Recommendation Report for Lawful Development Certificate for a Proposed Use or Development

REF NO: EP/25/20/CLP

LOCATION: The Millstone
Sea Lane Close
East Preston
BN16 1NQ

PROPOSAL: Lawful development certificate for a proposed rear box dormer and new rear doors at ground level.

1437/P02

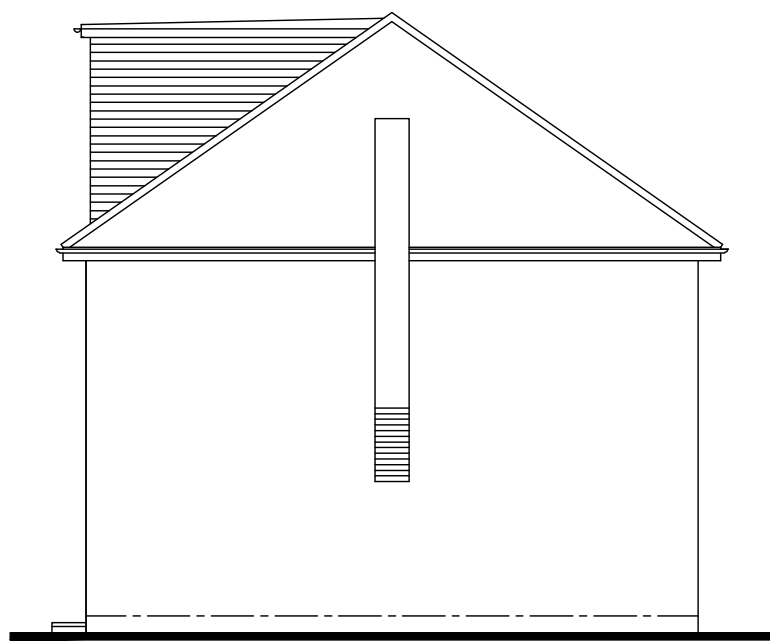
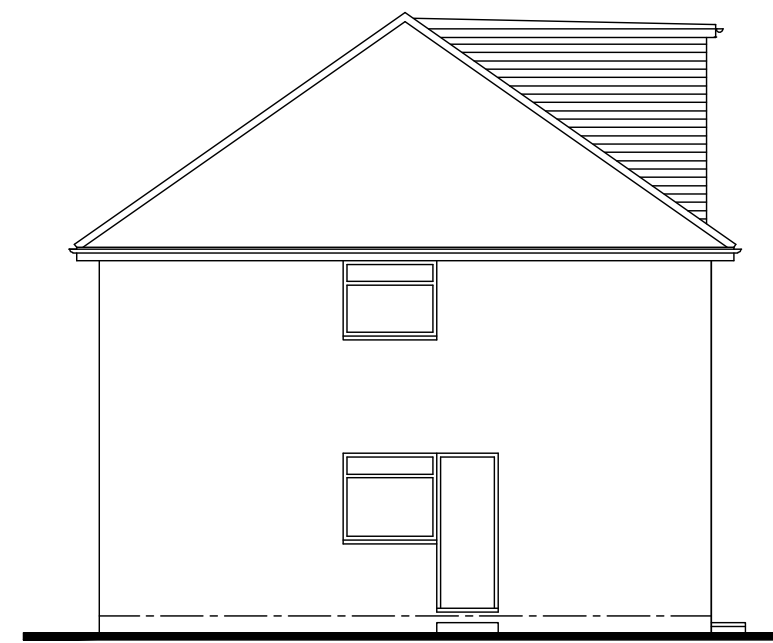
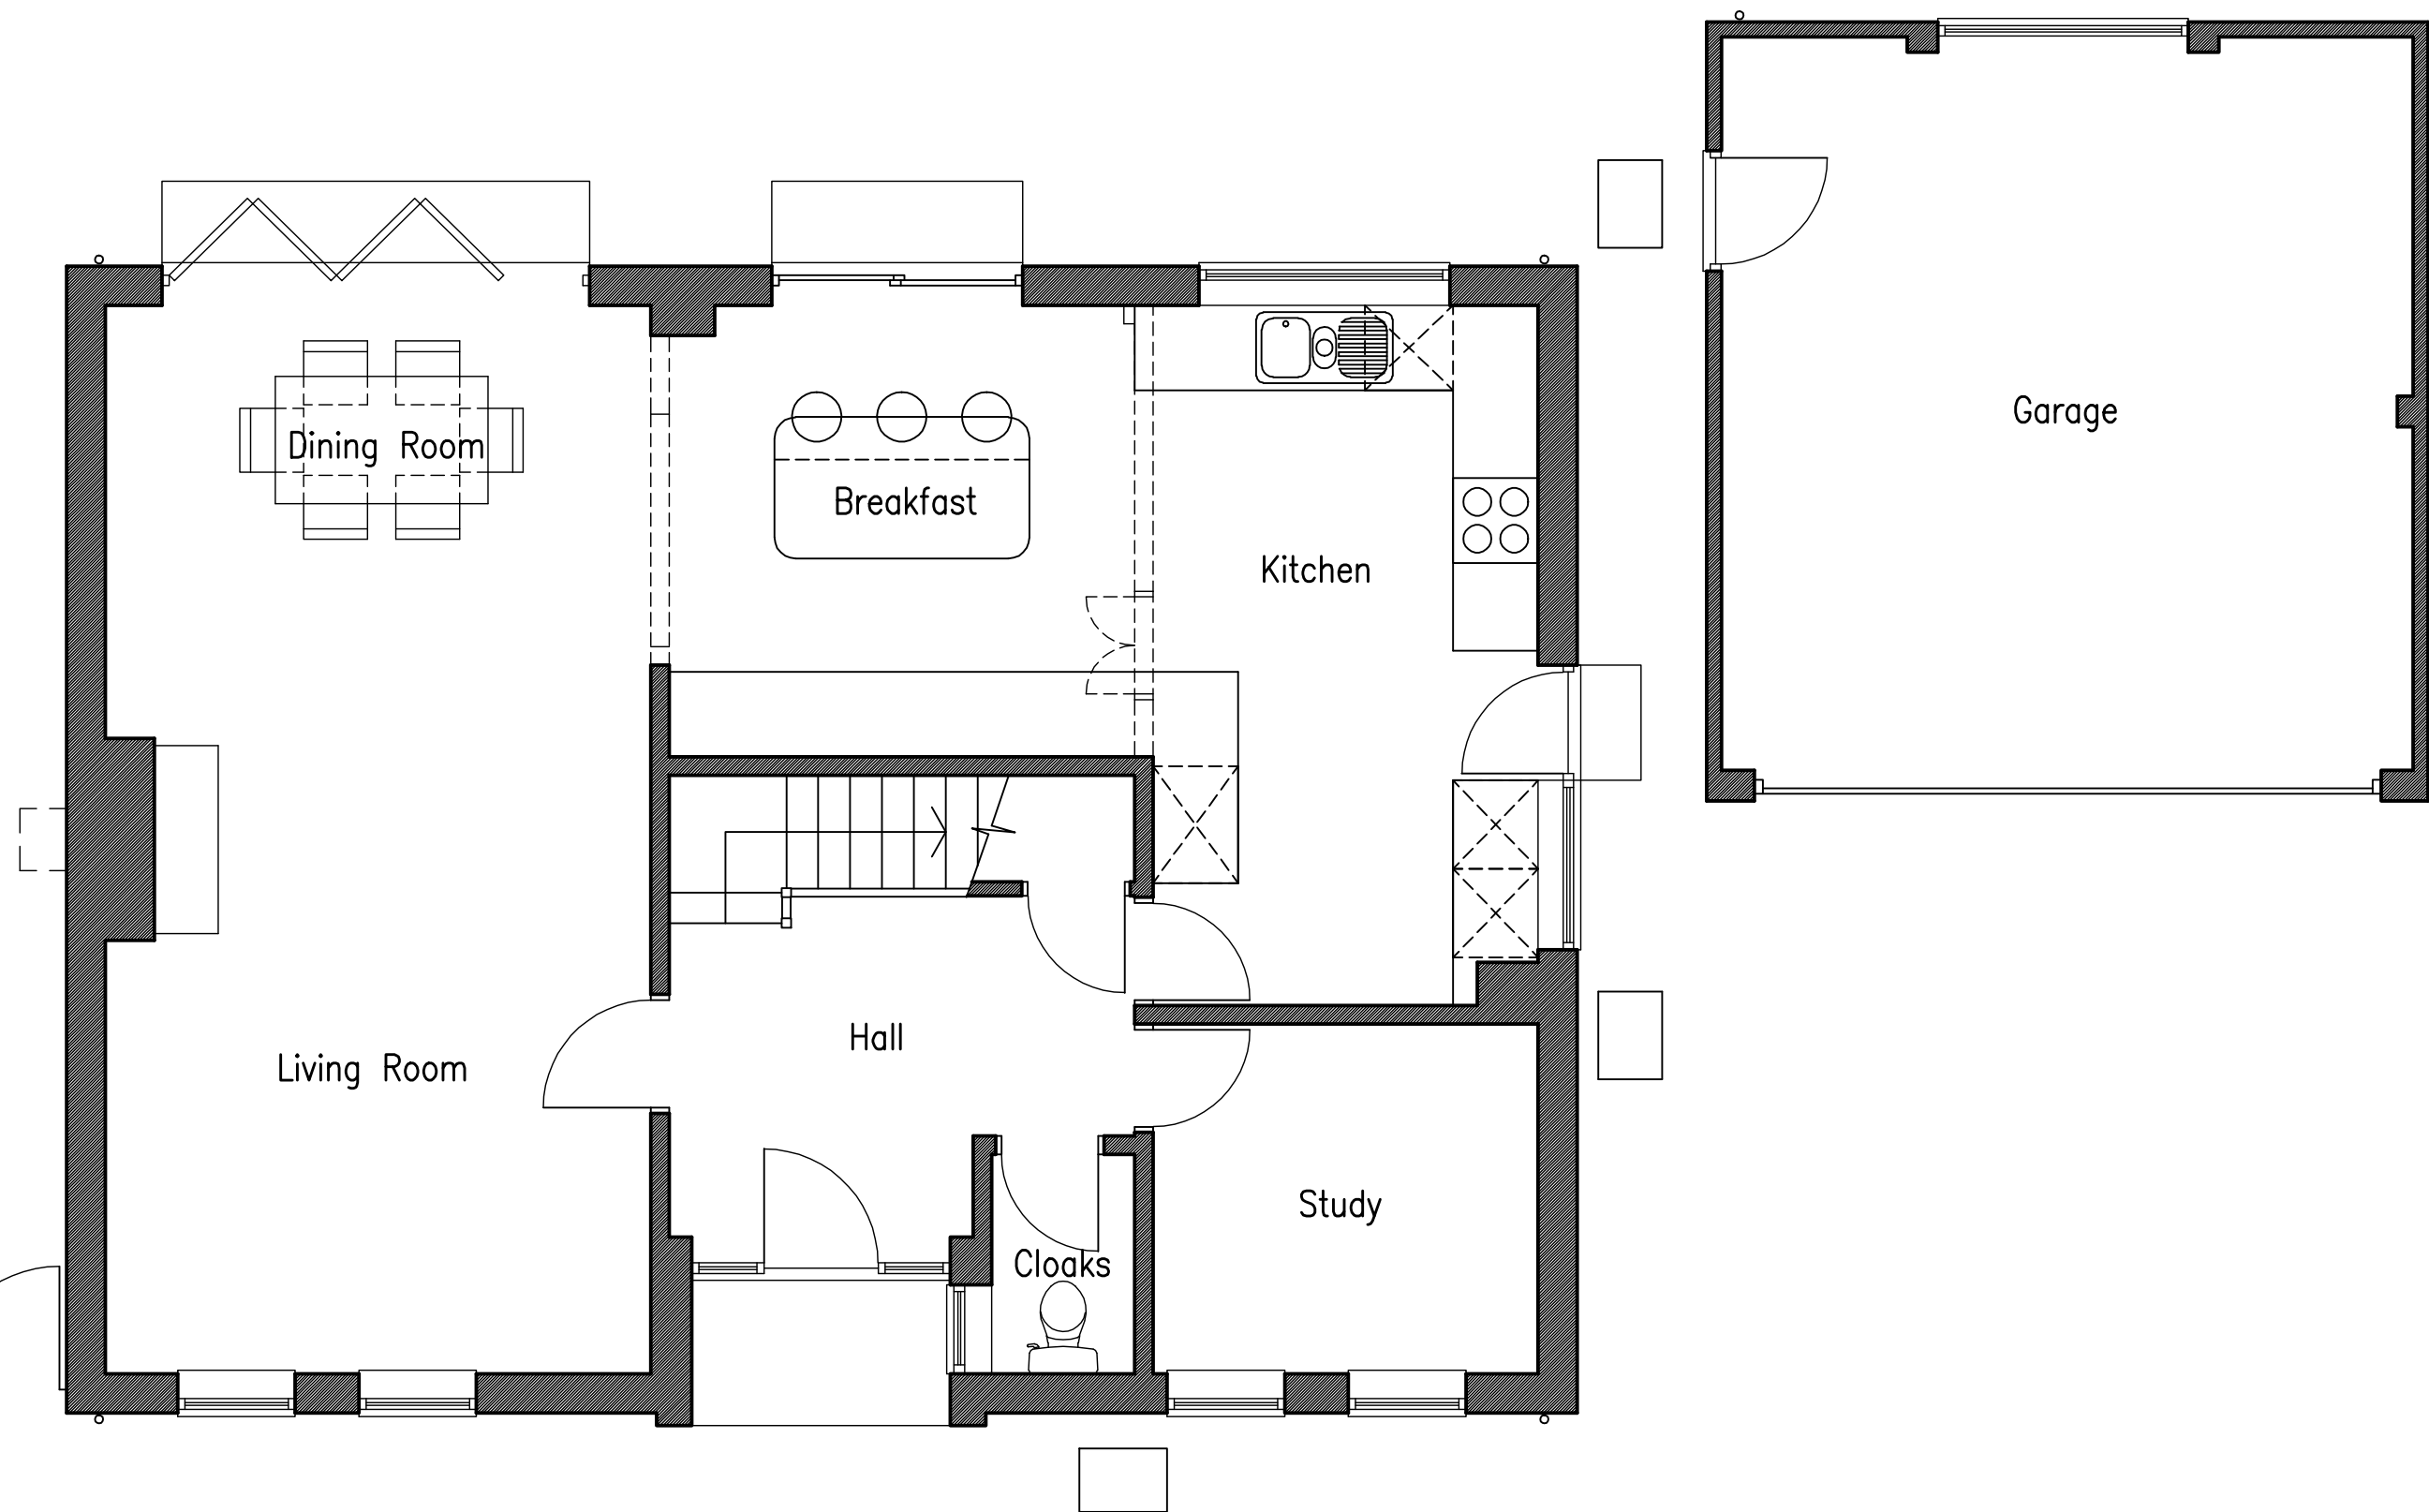
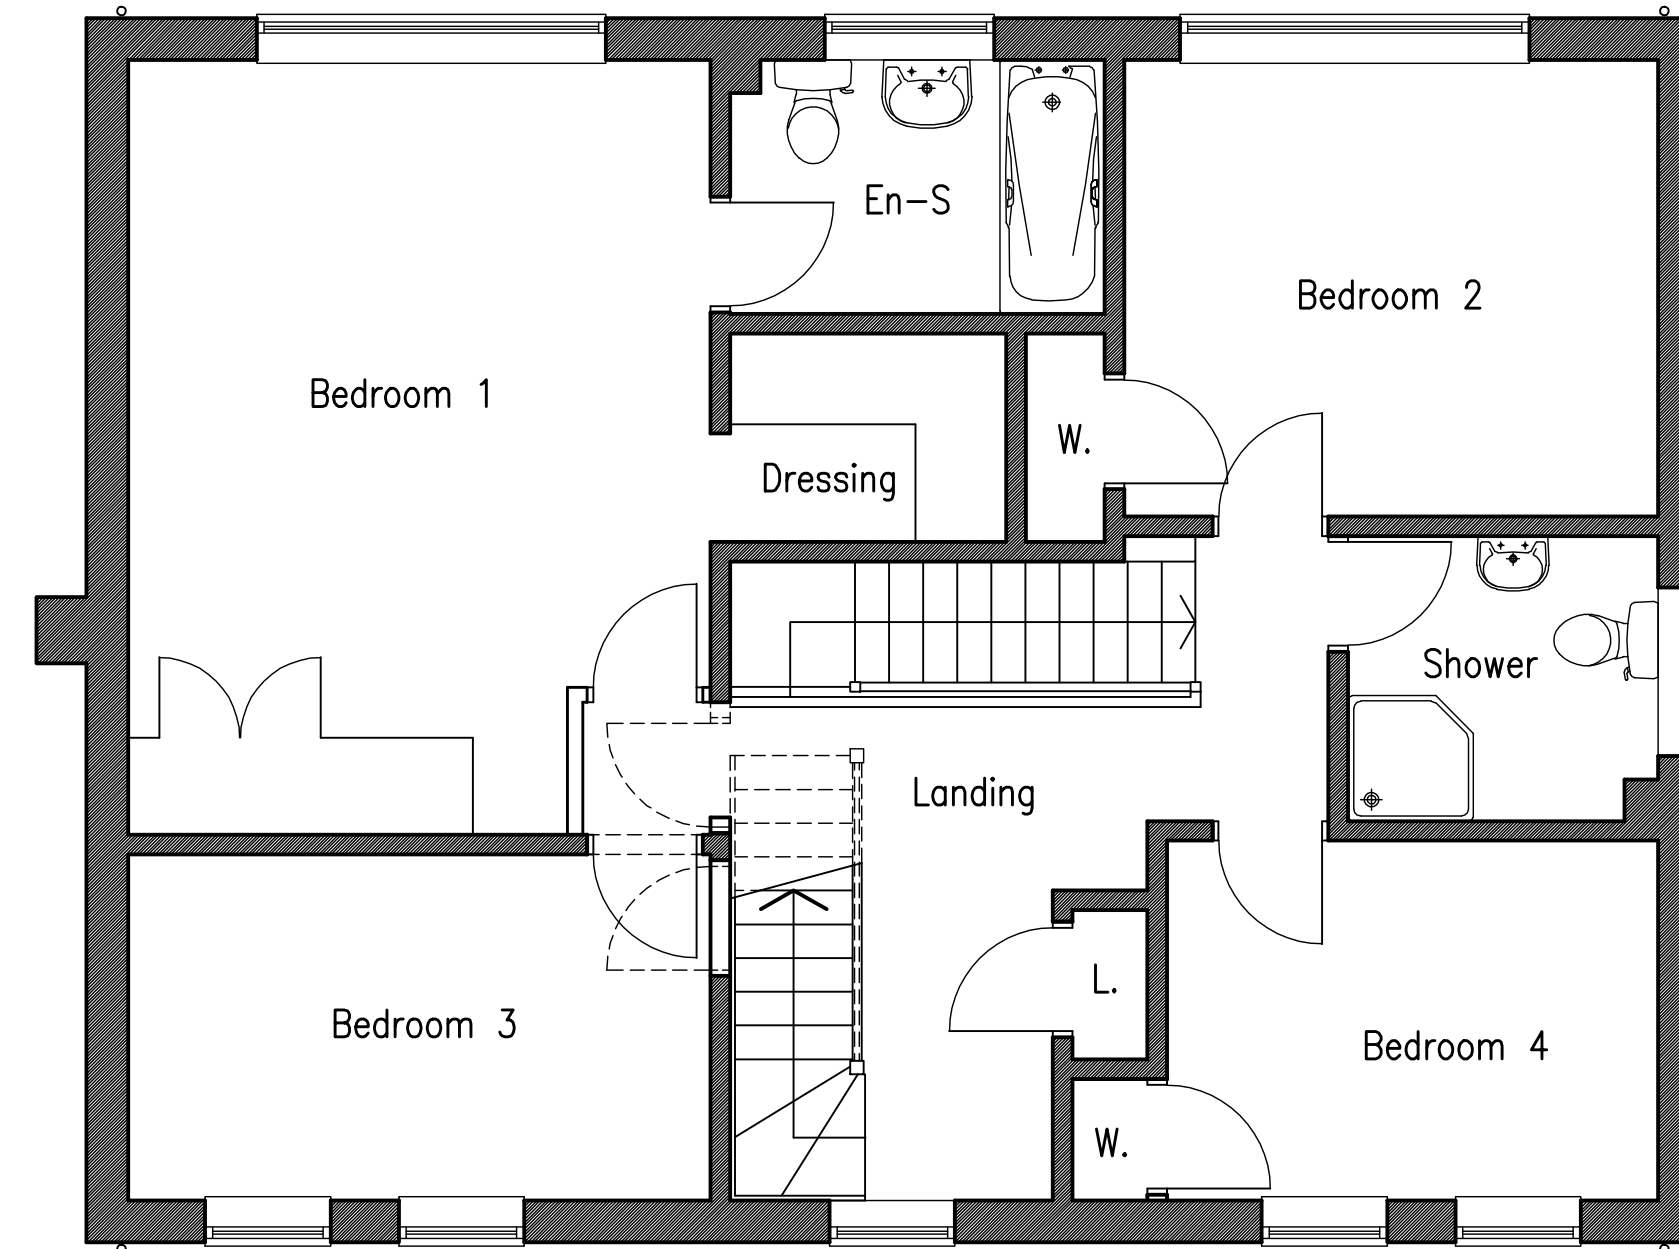
The dormer complies with the relevant sections of Schedule 2, Part 1, Class B of the GPDO, and is permitted development and does not require the submission of an application for planning permission.

The proposed insertion of the rear doors are not considered not to have a material impact on the external appearance of the dwelling, and is acceptable in accordance with Section 55 (2)(a)(ii) of the Town & Country Planning Act. Furthermore, they are also considered to be in accordance with Schedule 2, Part 1, Class A of the GPDO.
